Recommendation Report for Planning Permission for Works or Extension to a Dwelling

REF NO: P/113/19/HH

LOCATION: 4 Lion Road
Pagham
PO21 3JZ

PROPOSAL: Single storey rear extension.

Proposed :

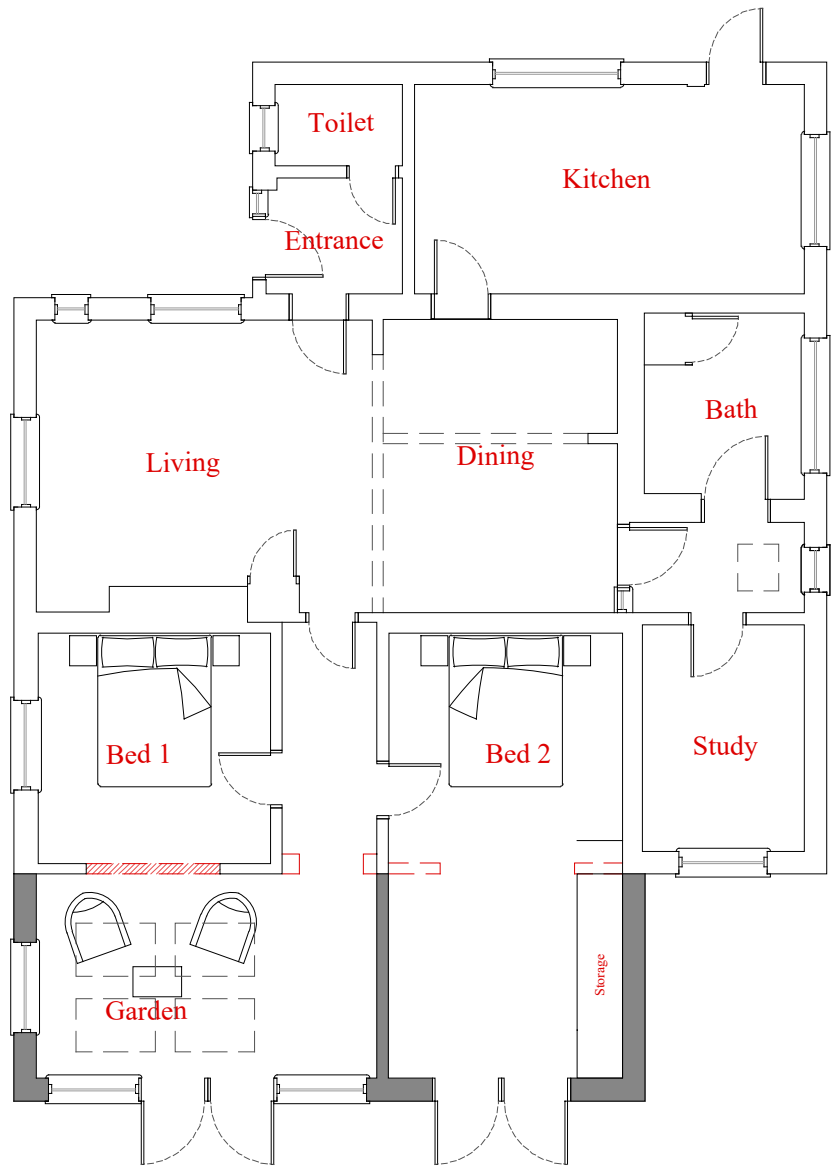
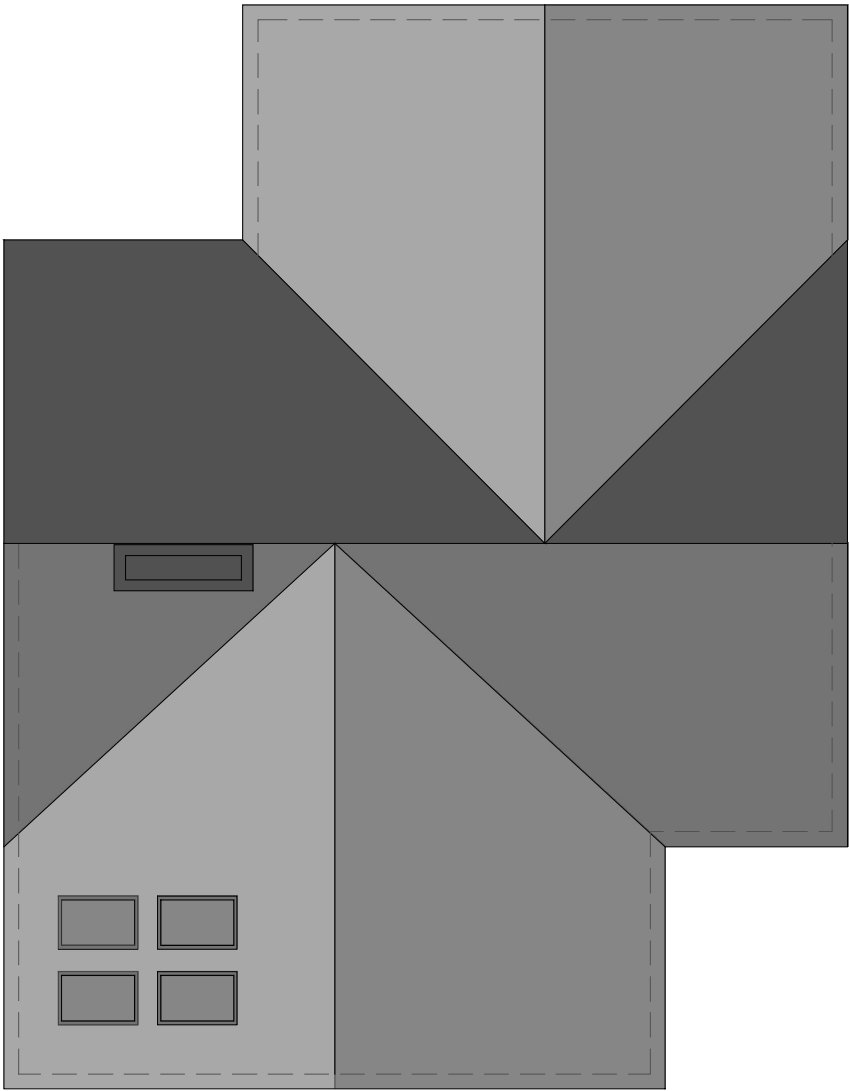
The applicant seeks planning permission for the construction of a rear extension to the established dwelling. The proposed new development will measure approximately 4.4m wide, 3m in depth to the rear and be built to the proposed height of 2.2m at the eaves height with a pitch height of 4.8m to match that of the existing dwellinghouse.

The proposed rear and side extension will be located approximately 27m from the southern boundary and 2.5m from the eastern boundary and 4.25m from the southern boundary. On the western elevation there is one proposed window looking out to the rear garden and the boundary hedging. There are also 4 proposed skylights to allow for sunlight into the garden room. On the southern elevation there will be 2 No. sets of French Doors and 2 No. proposed windows, two to pair the French doors in the sun room. The eastern elevation will remain solid brick to avoid overlooking. The views gained from the windows and doors are not considered to cause overlooking as they are all single storey and look out over the rear garden of the property. The views gained will be no greater than those currently available from the garden.

Elevations

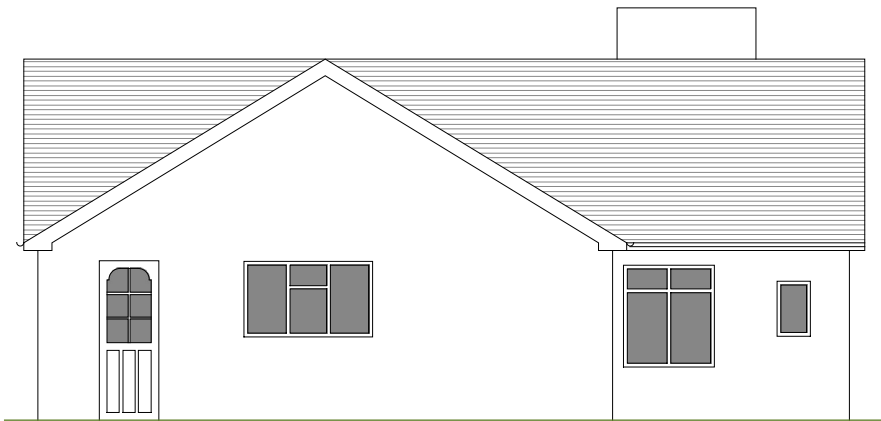
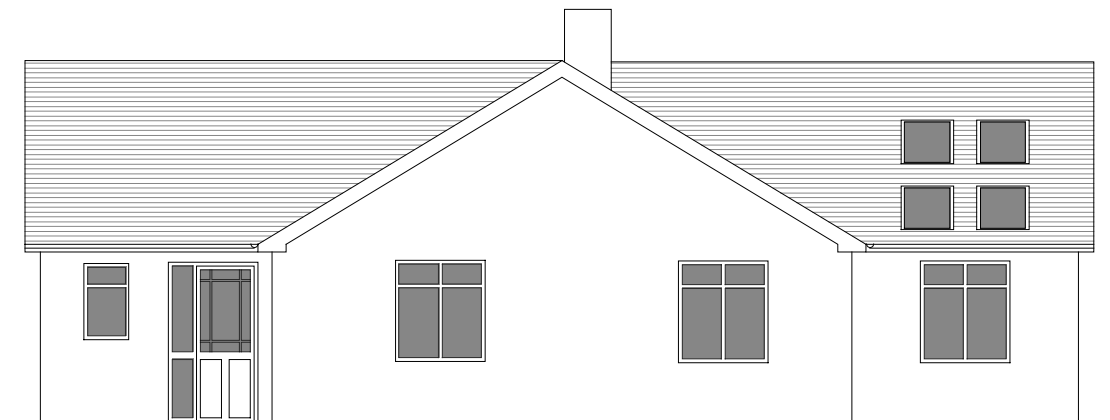
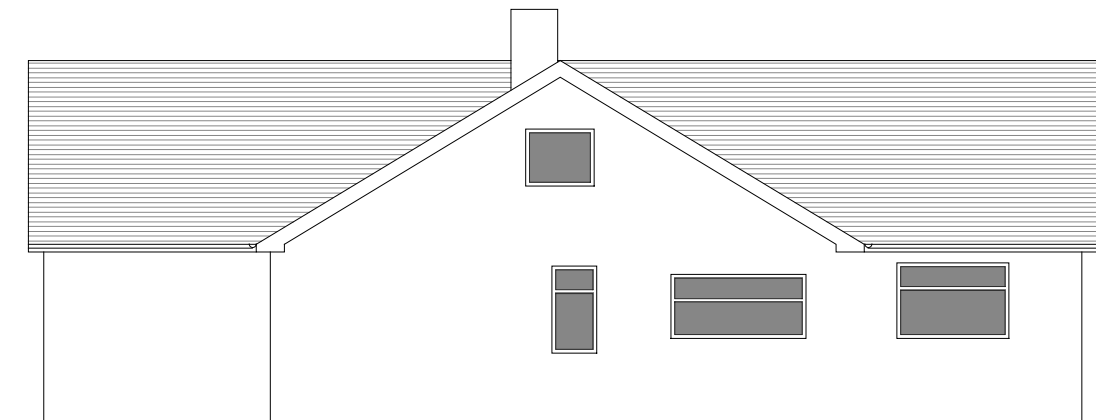
The proposed extension given its location will be visible from the street scene despite the high screening on the boundary due to the proposed connecting to the existing at pitch height. Due to the nature of the application and the street having other extensions/conversions of a similar nature it is not considered to have a detrimental impact on the character of the host dwelling or the street scene. The proposed extension is considered to result in any adverse impact on the spatial pattern or character of the area and would therefore accord with the policies D DM1 and D DM4 of the Arun Local Plan.
